**Consultation Response from KC,
Lead Local Flood Authority**
2021/93750 adj, 360, Lees Hall Road, Thornhill Lees, Dewsbury, WF12 9EW
Erection of 9 dwellings
**Date Responded: 7th
November 2021**
**Responding Officer: Paul
Farndale**
Responding Ref:
Summary – Sequential Test and Approach

Proposed Drainage Layout
1/250

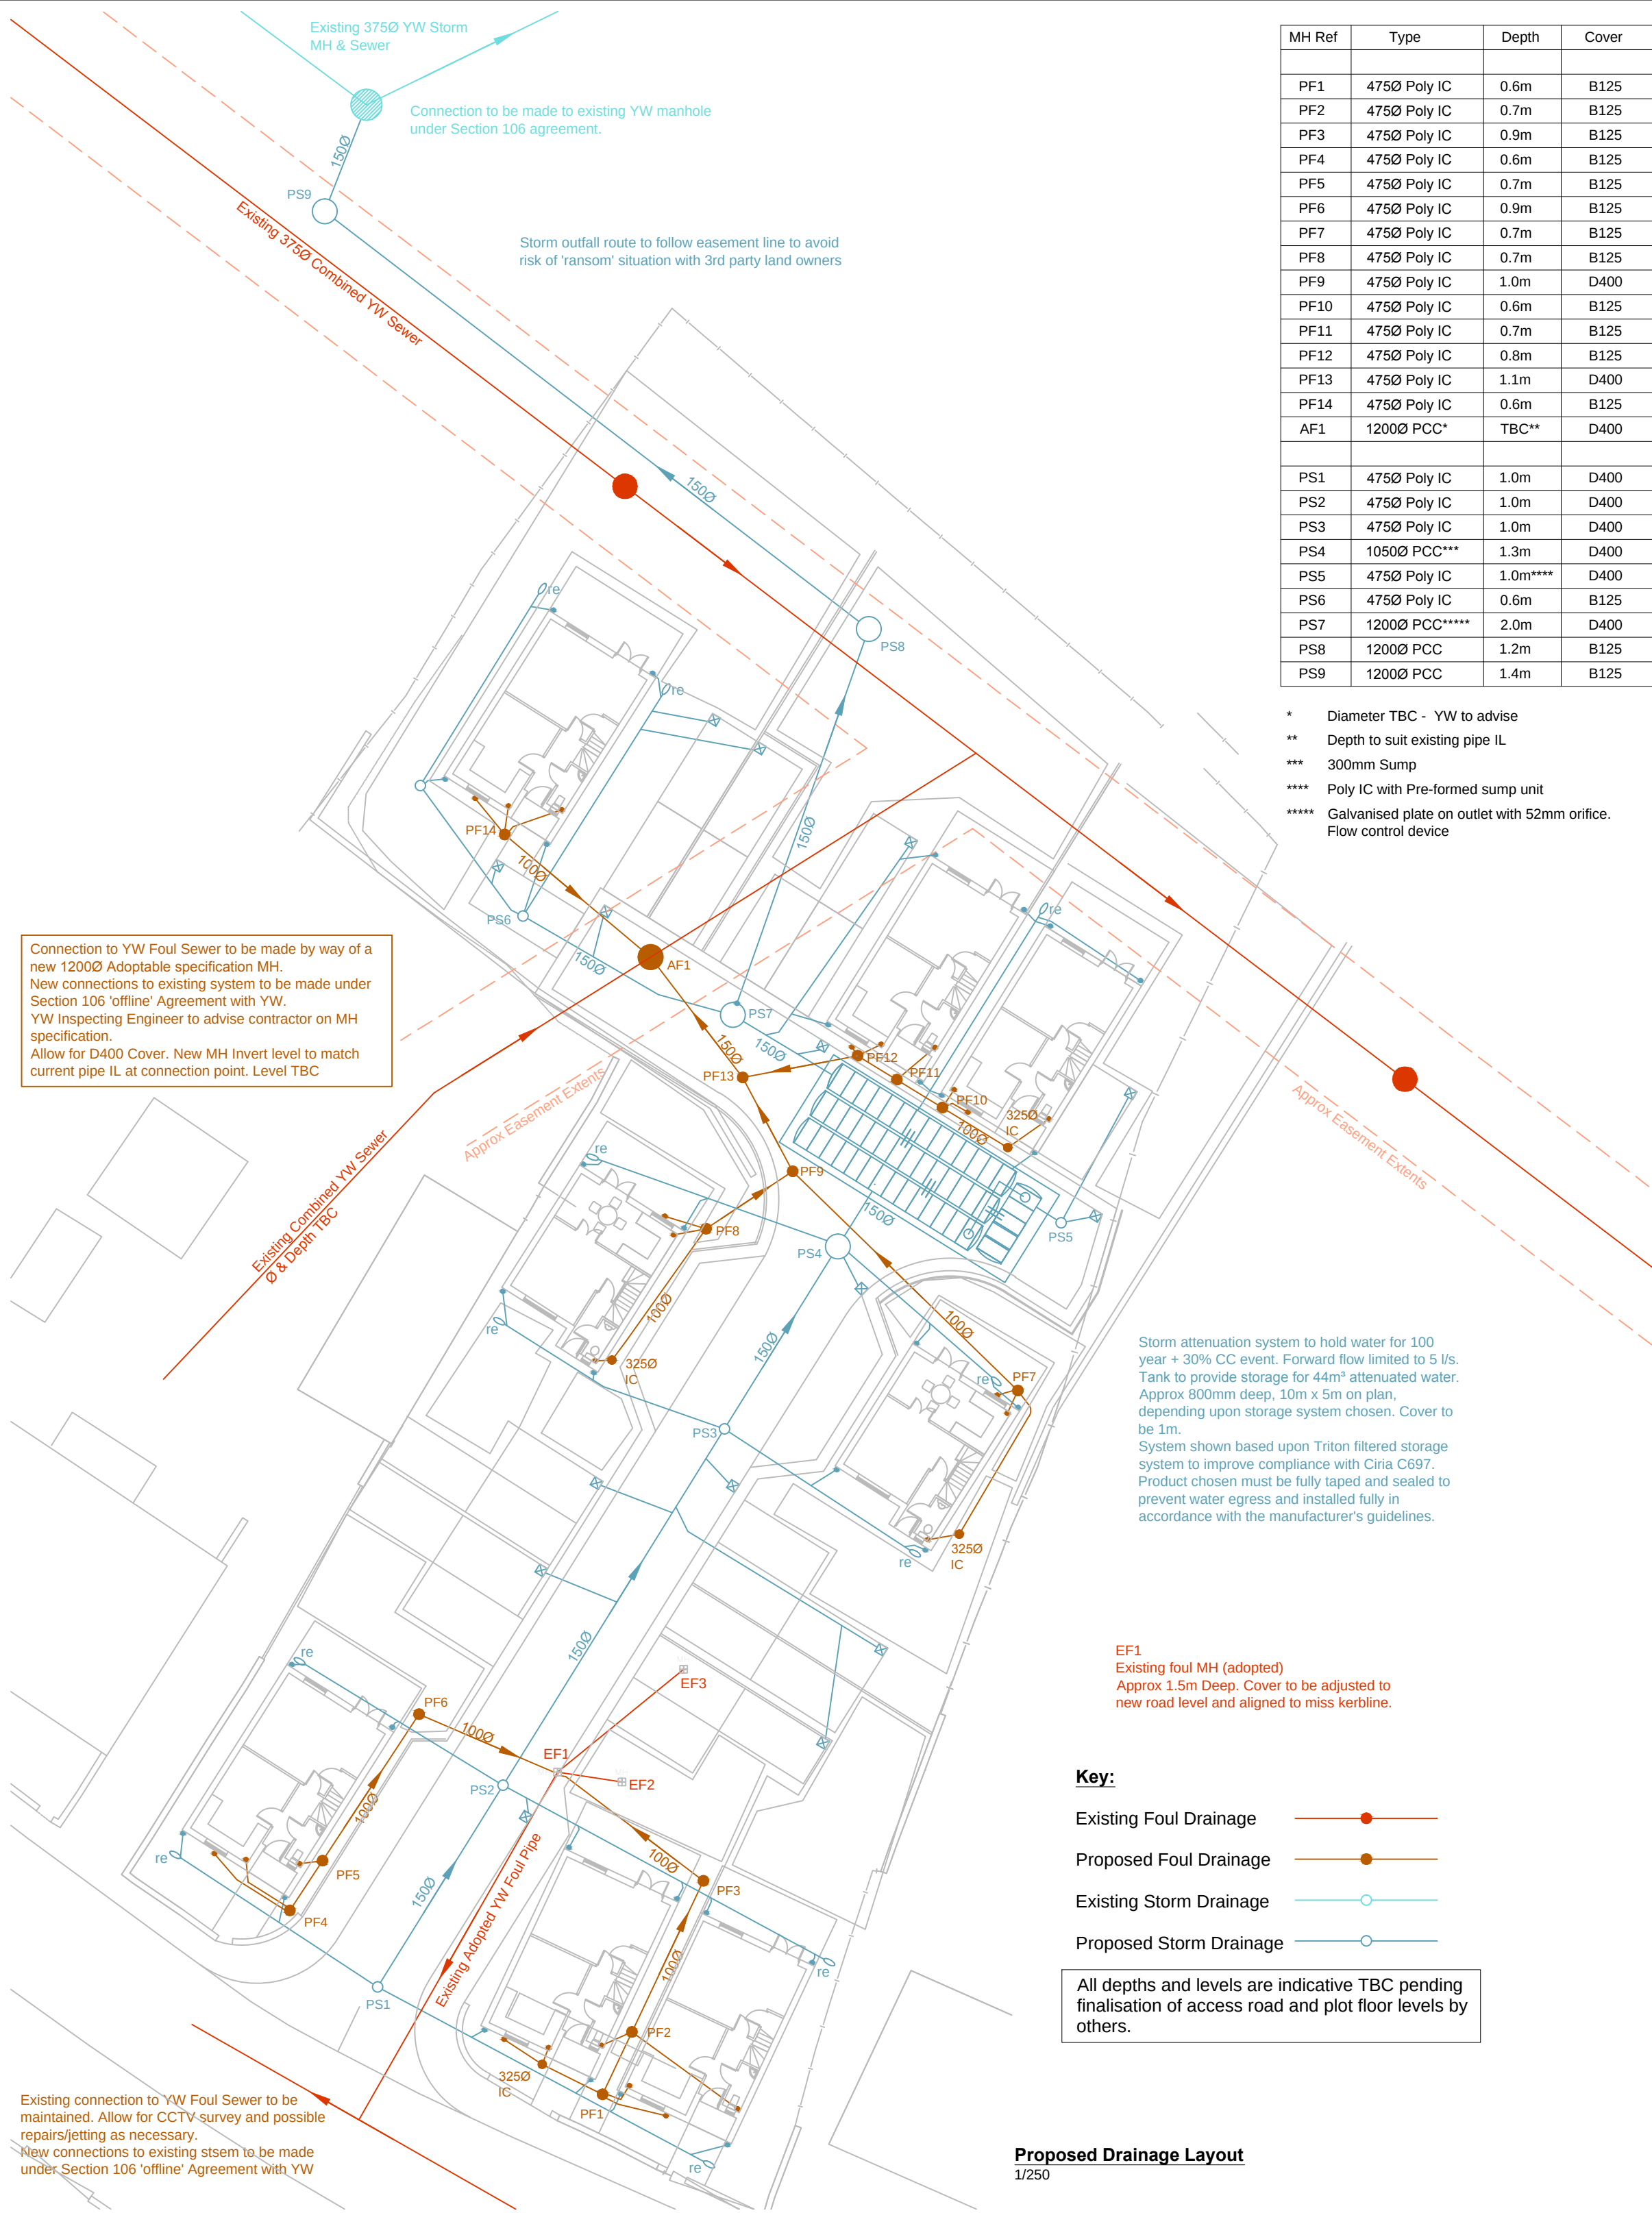
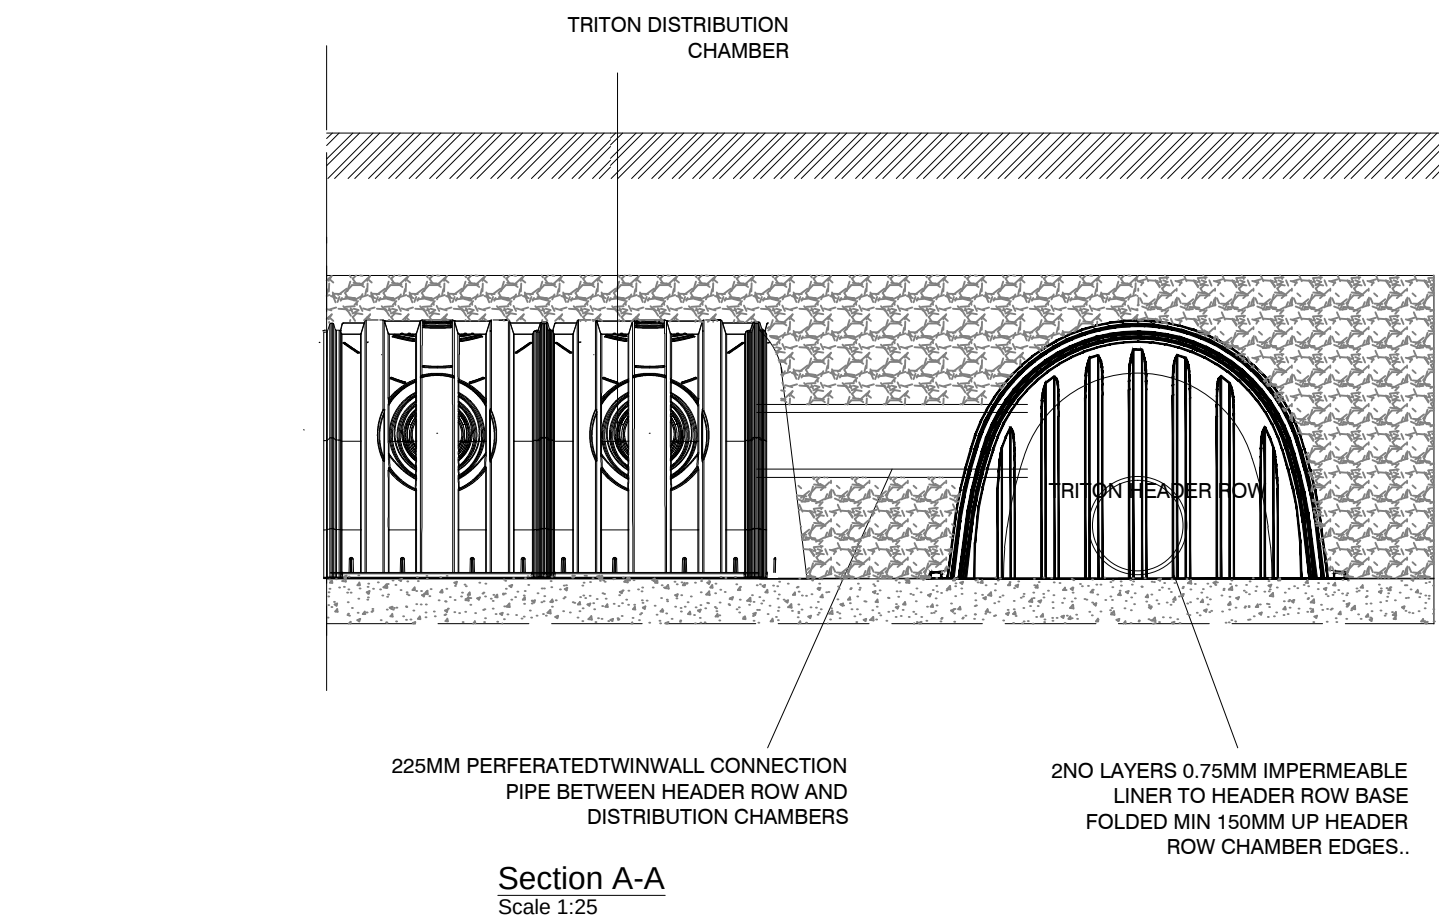
- The location of section 24 public sewers for existing buildings to be demolished and to remain must be established and incorporated, potentially by diversion, with suitable stand off distances. The layout should be designed around this constraint and not the other way round.
- Surface water flood risk for the 1 in 100-year event encroaches at the northern boundary and estimates up to 600mm depth. For similar reasons, this must be assessed in an FRA and property and curtilage avoid this area. It is likely to coincide with main river flood risk boundaries.

- As an advice note, attenuation under the highway with a span greater than 900mm will be labelled as a structure and will likely preclude the road being adopted by the highway authority. This does not mean a suitable attenuation tank of such a dimensions cannot be approved by the planning authority and the road remain private.
- It is noted that Yorkshire Water would consider a discharge to public surface water sewer from the site at 5l/s. The note from 2016 does not approve this figure. Kirklees LLFA would not oppose this or reduce this figure if firm approval from a consultation is received from Yorkshire Water.
- The flood zone map incorporated in the out-of-date Flood Risk Assessment is mislabelled. Both boundaries are labelled 1 in 100-year return periods.
- The area is unsuitable for infiltration being listed by British Geological Survey as category 4 – severe constraints.
